# CITY OF ALBUQUERQUE

**RE: Jackson Middle School  
Grading and Drainage Plan  
Engineer's Stamp Date 11-11-16 (File: J21D029)**

Based upon the information provided in your submittal received 12-28-2016, the above referenced plan is approved as noted for Building Permit:

**BUILDING A
~CAFETERIA~
GRADING & DRAINAGE
PLAN**

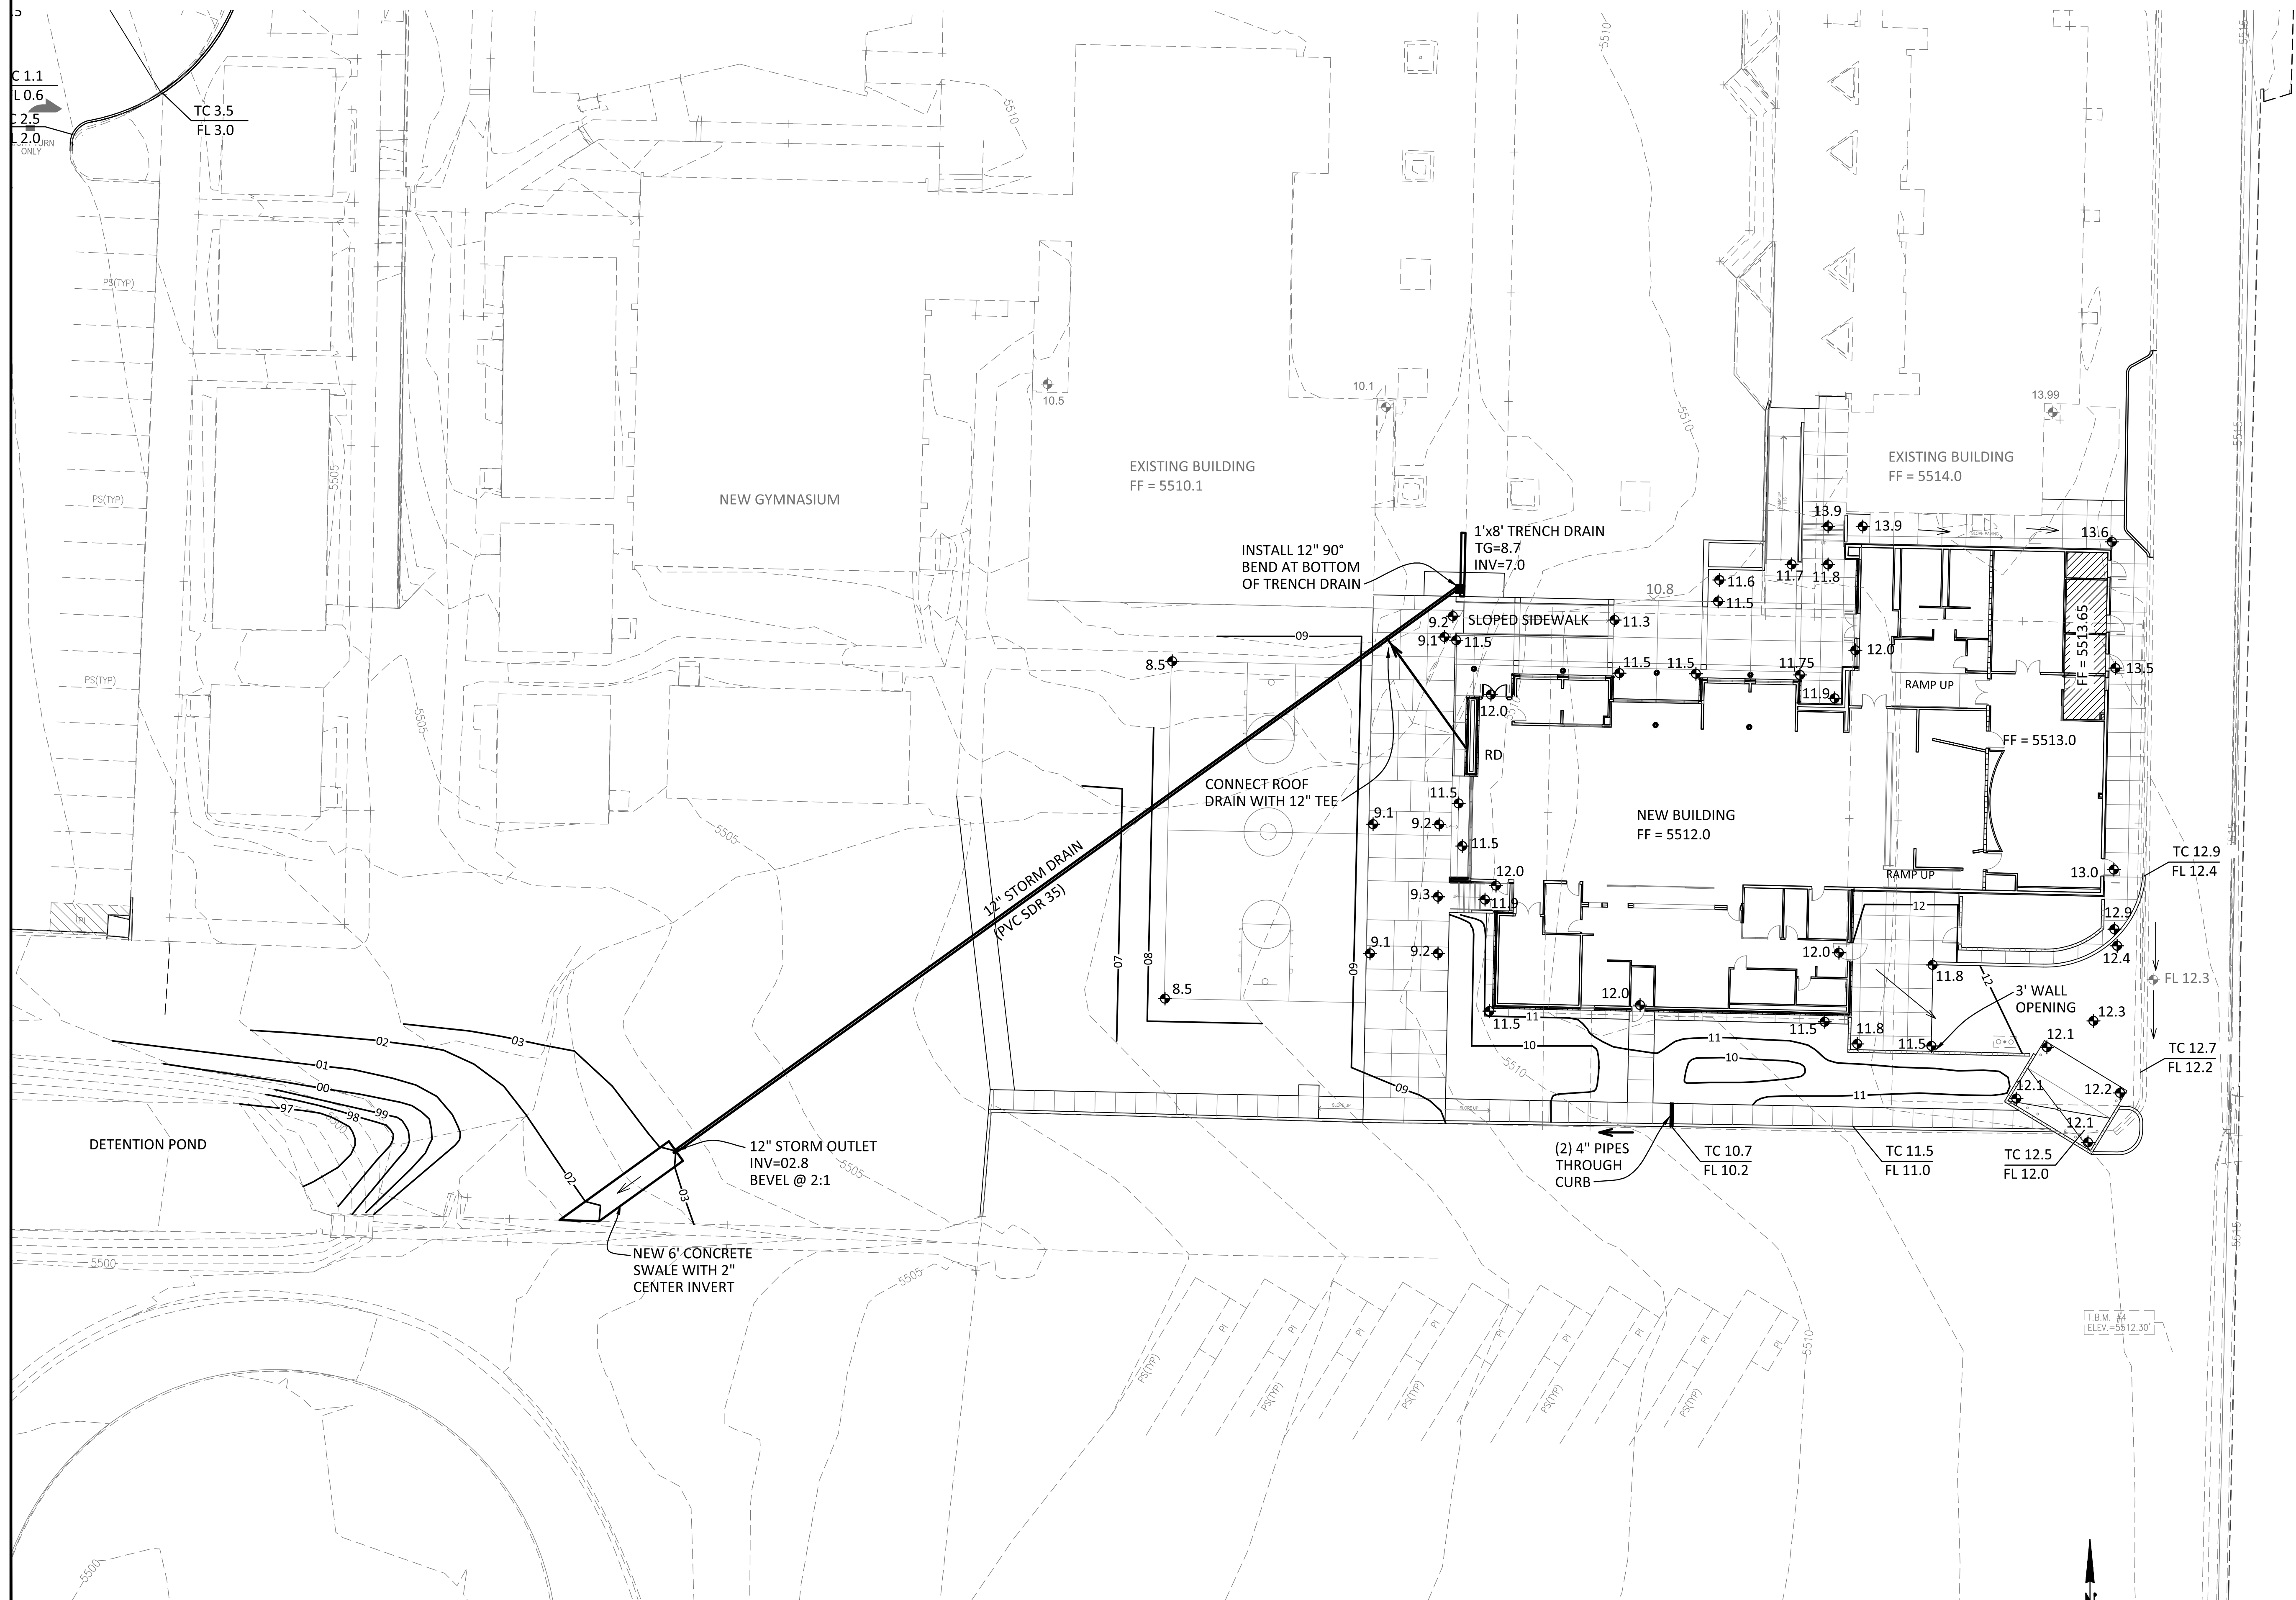
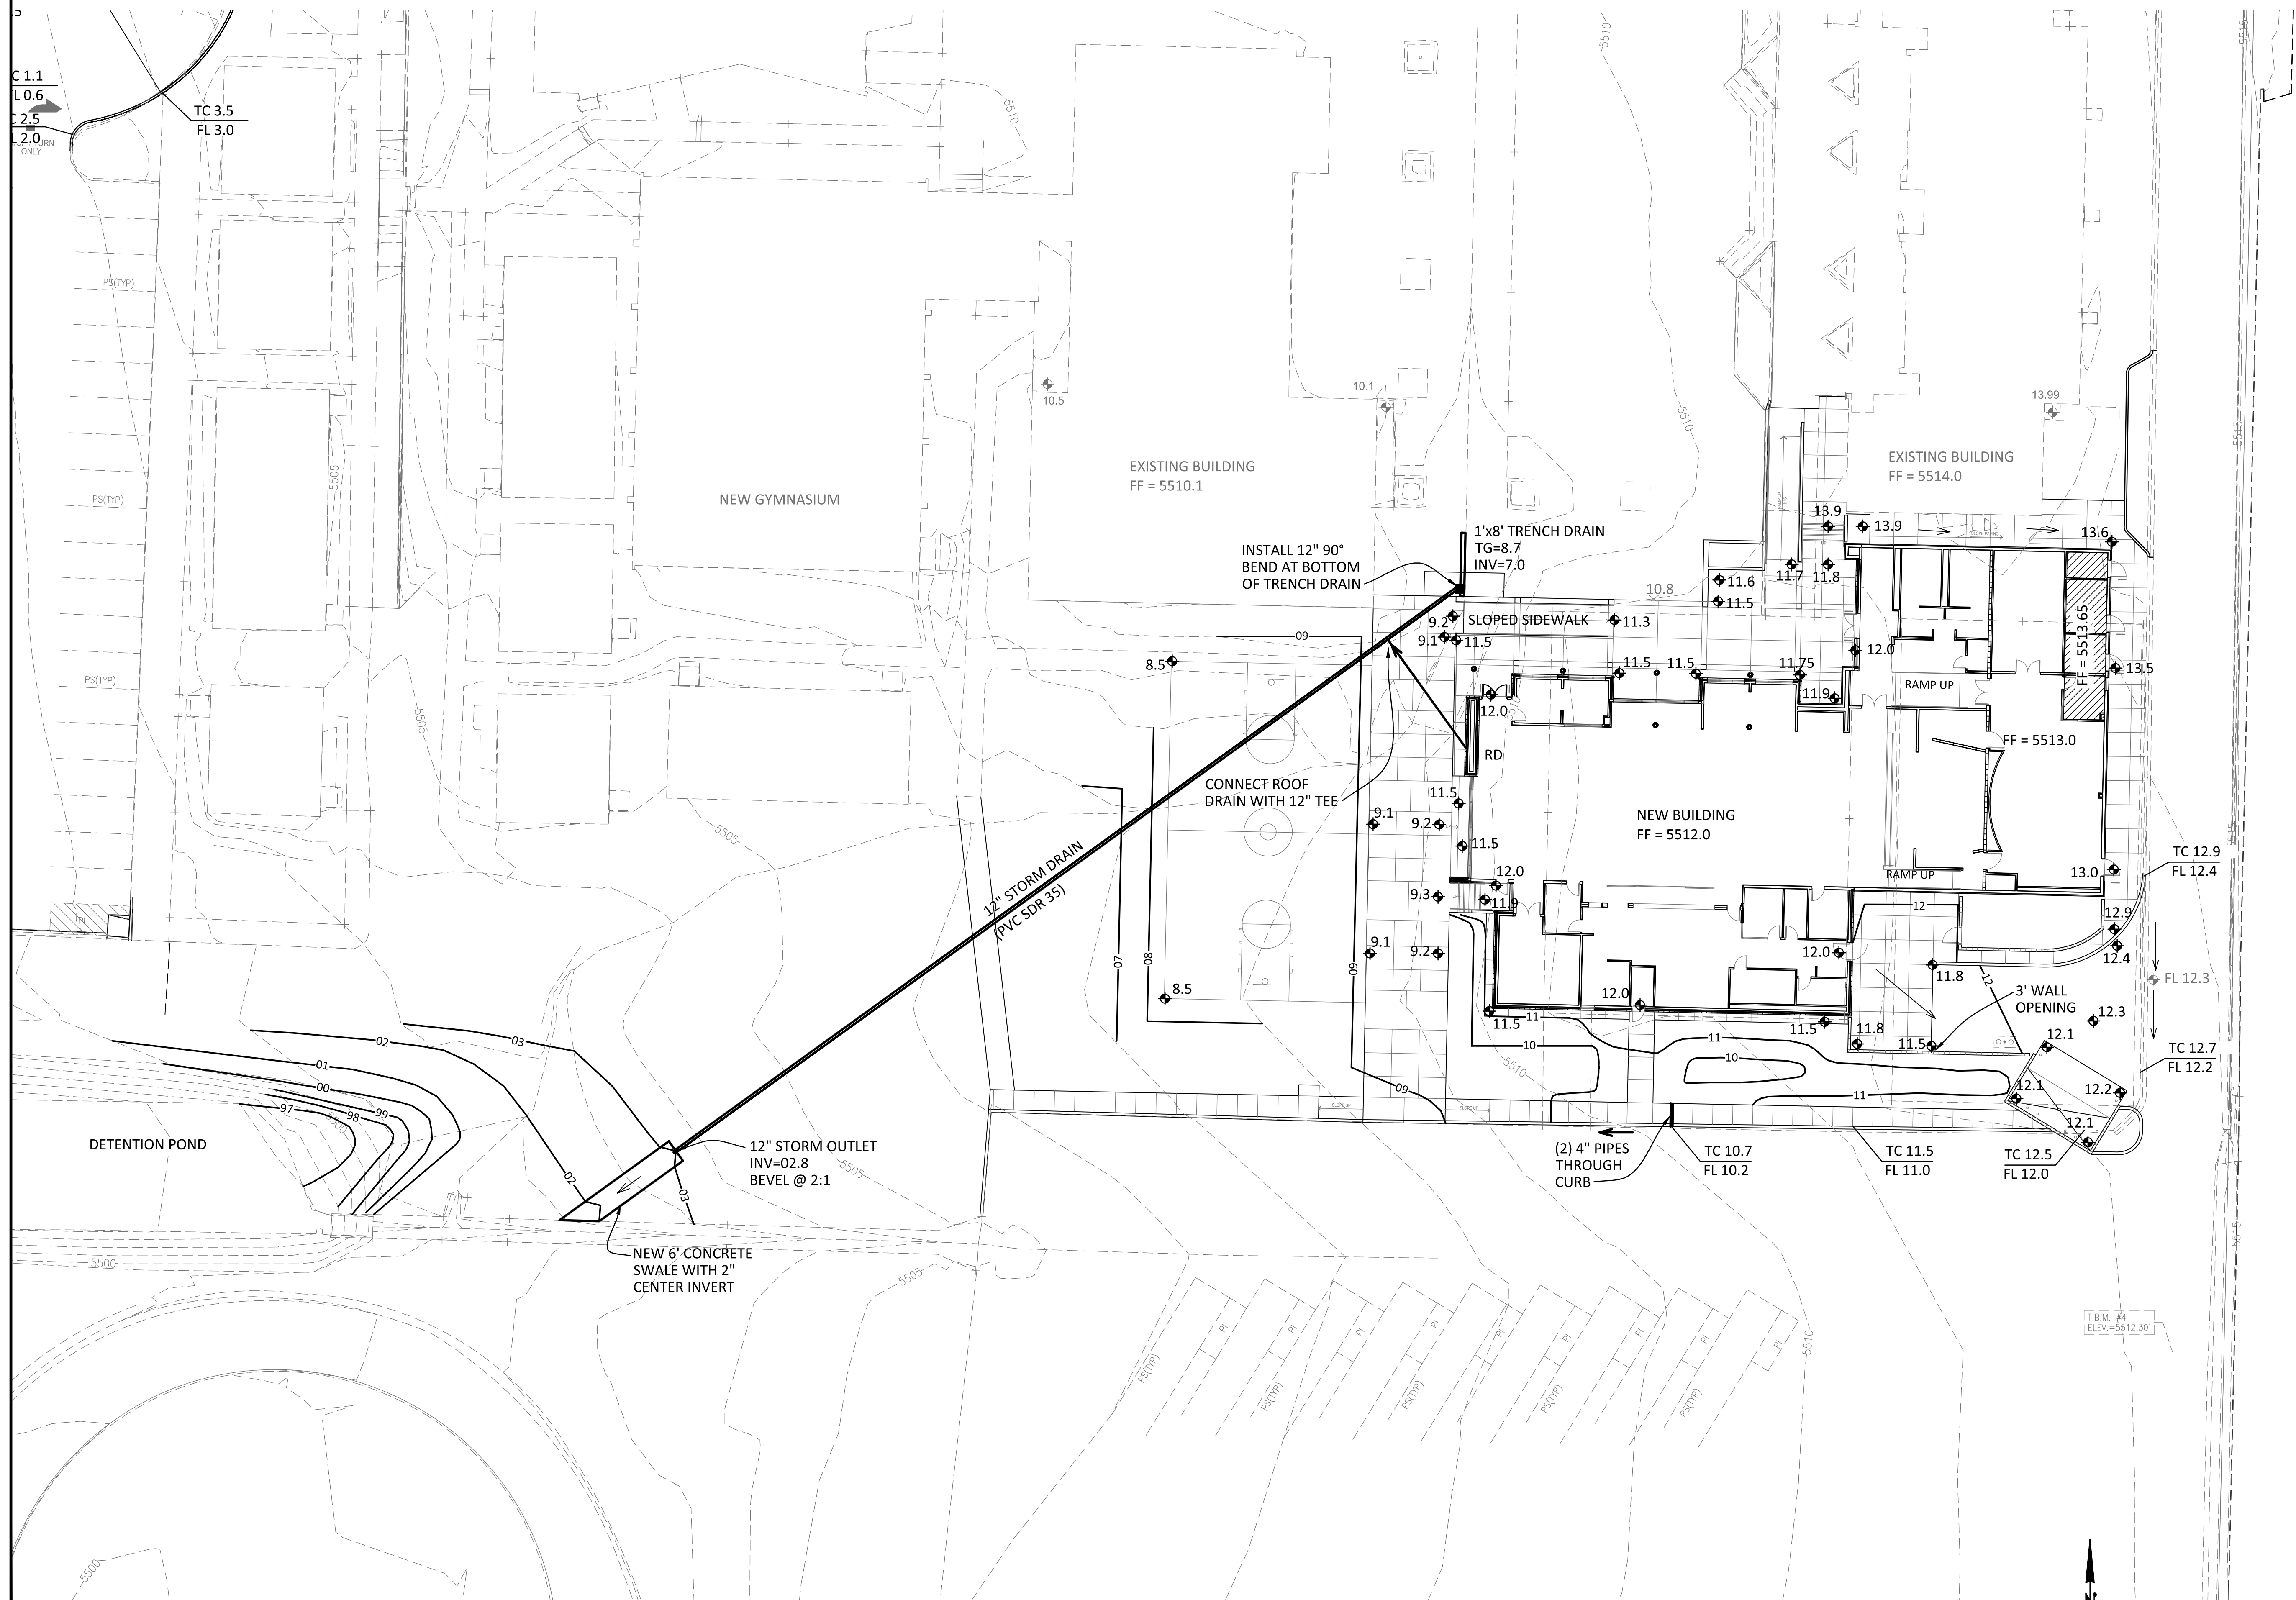
1. The Drainage Approach concludes with flows from the shallow depressed landscaping area being directed northward into a parking area and toward Comanche. No mention of directing flows into the storm drain and southwest towards the detention pond is made. Clarify the last portion of the Drainage Approach to match what is shown on drawings.

The approach as shown on drawings, acceptably conveys flows from the impervious areas through storm drain or overland, to the enlarged detention pond, whose outfall is Blume Street on City Right-of-Way. Additionally, it is recommended that erosion along the existing concrete rundown to the detention pond is corrected as part of this work.
